Location: Rose Cottage Edisford Road Clitheroe BB7 3LA
Proposal: Discharge of Conditions 9 (Surface Water Drainage)

Further to our review of the Drainage Layout Plan, Dwg Ref: 40-01, Rev. P7 - Dated: 18/06/21, United Utilities recommends that condition 9 is not discharged.

Site Plan

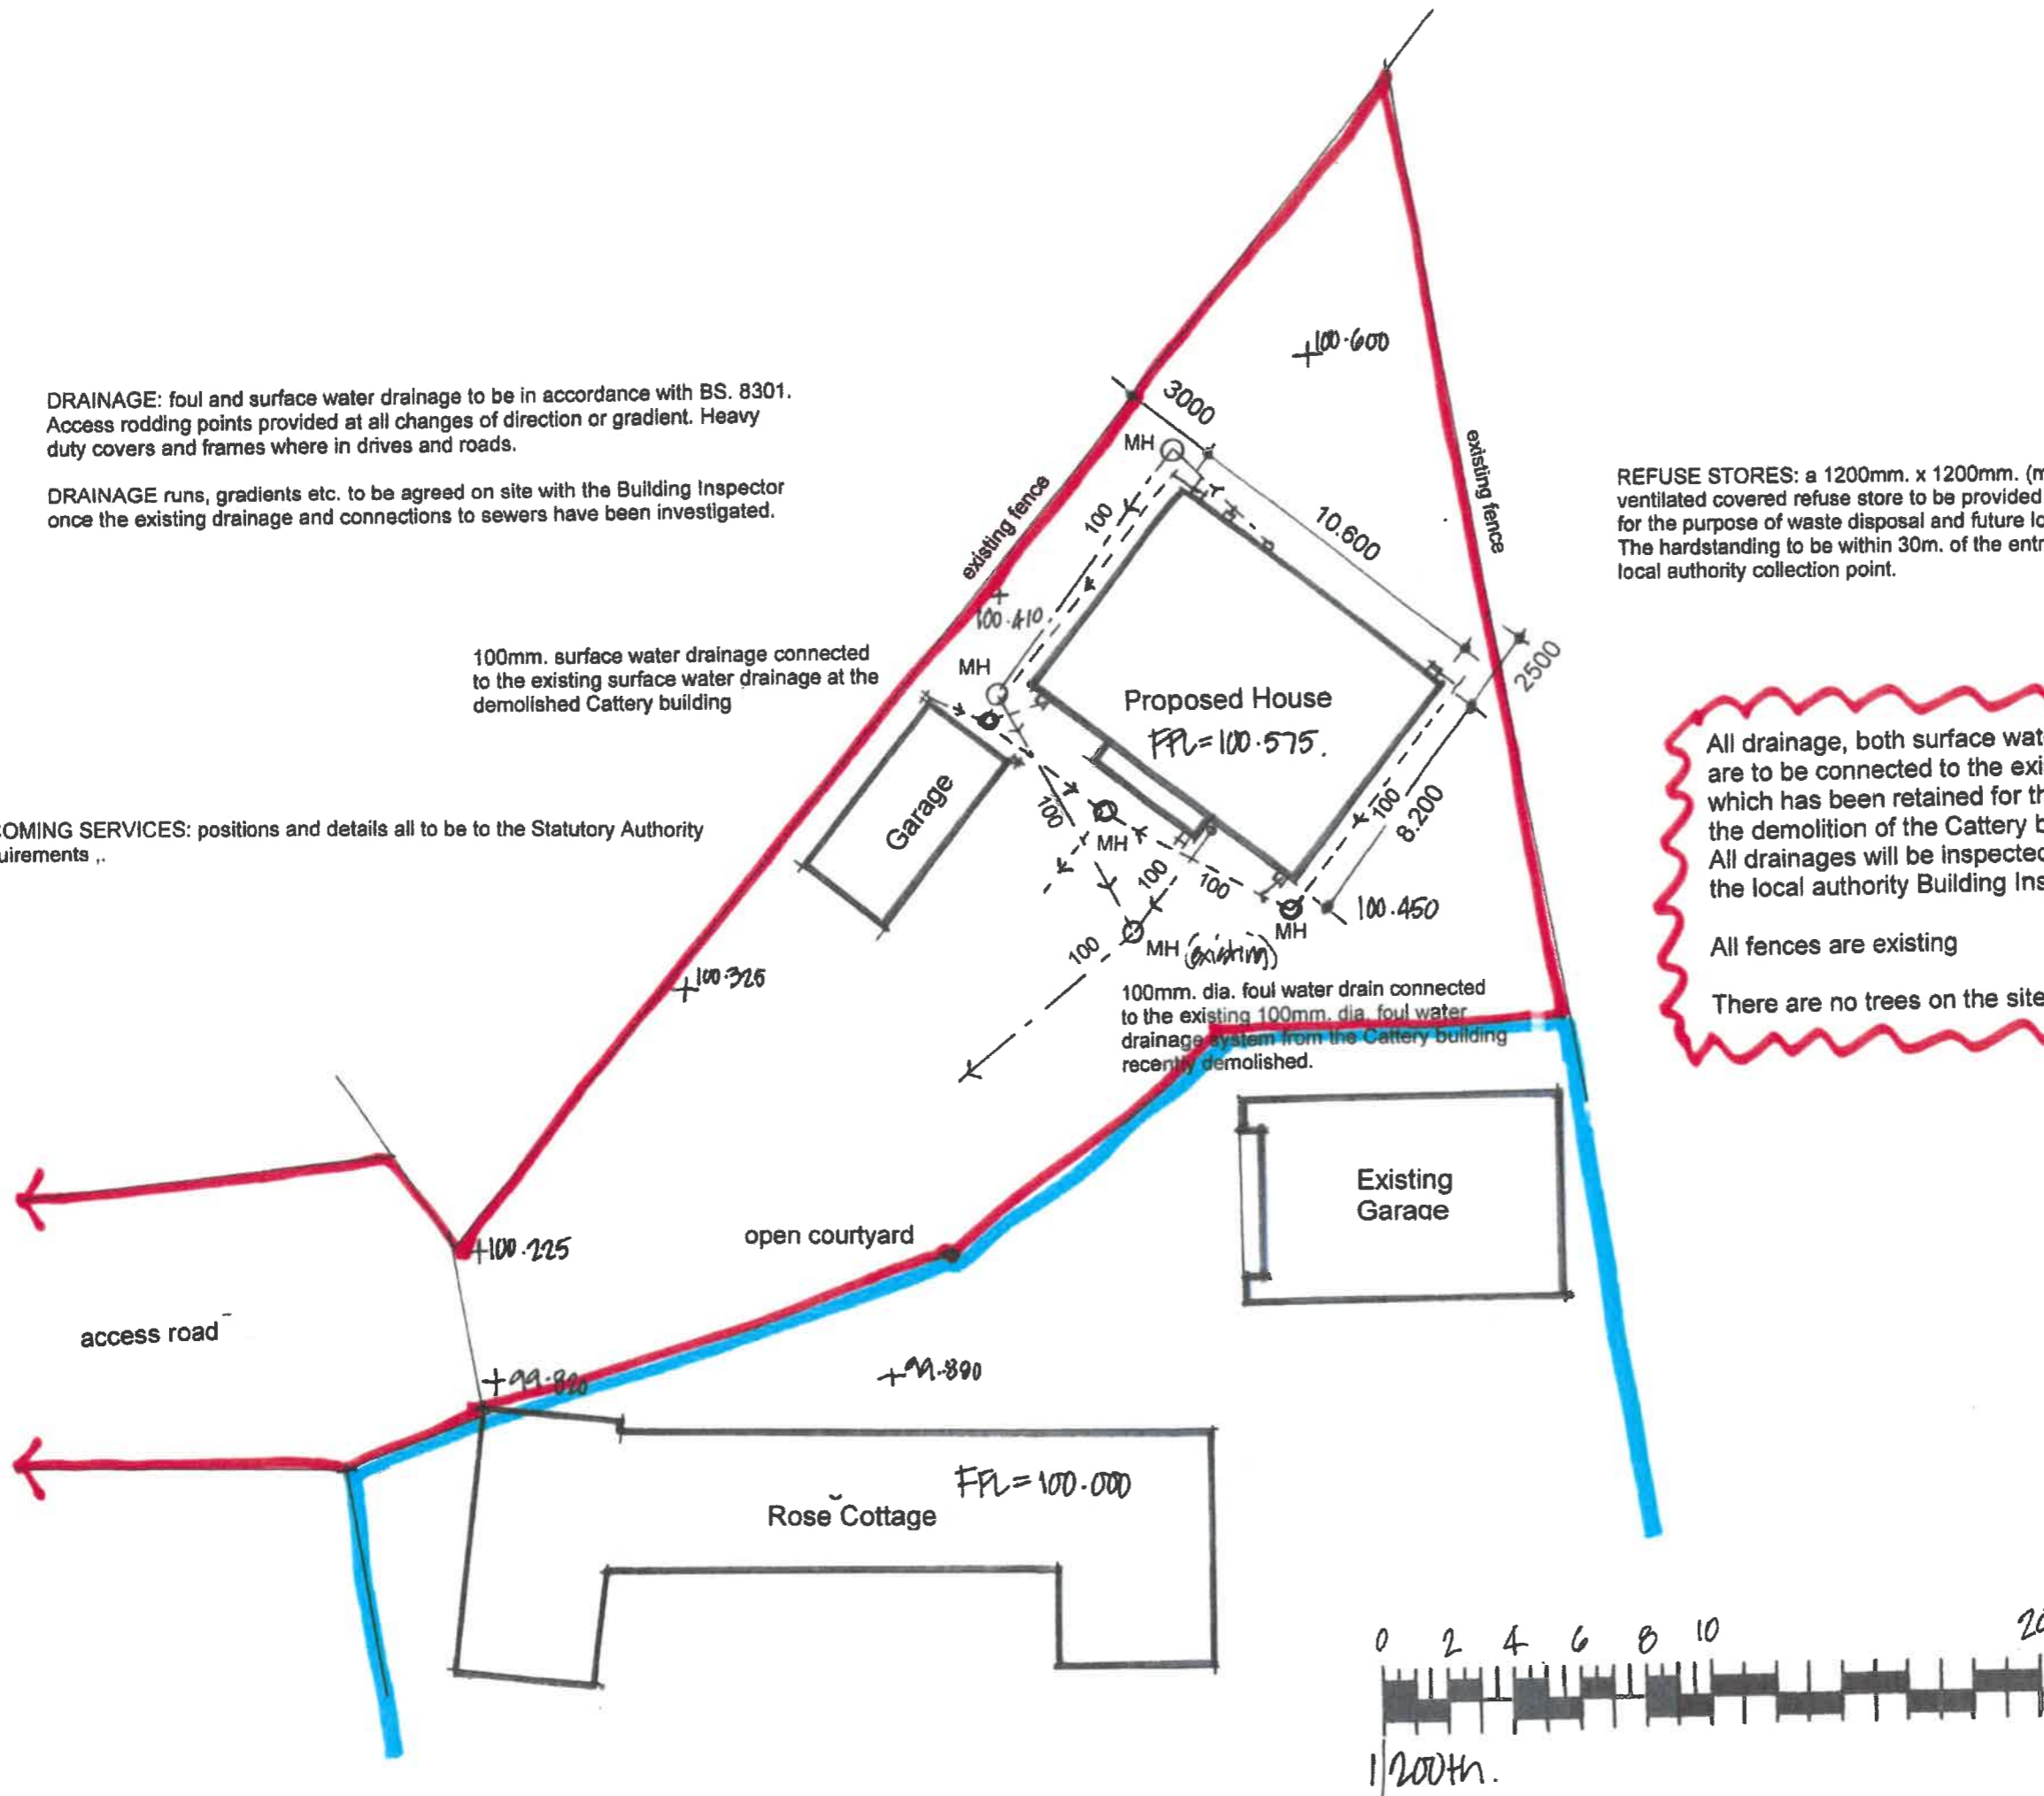
This is because robust evidence does not appear to have been provided to explore and exhaust the surface water drainage hierarchy, in line with the requirements of condition 9. Additionally, the ultimate point of outfall for surface water and foul appears to be unclear according to the drawing provided.

As well as showing evidence into infiltration, we require the drawing to be appropriately coloured in relation to surface water and foul, and to describe the level of surface water discharge in l/s, not exceeding 5l/s in the event that infiltration can be discounted.
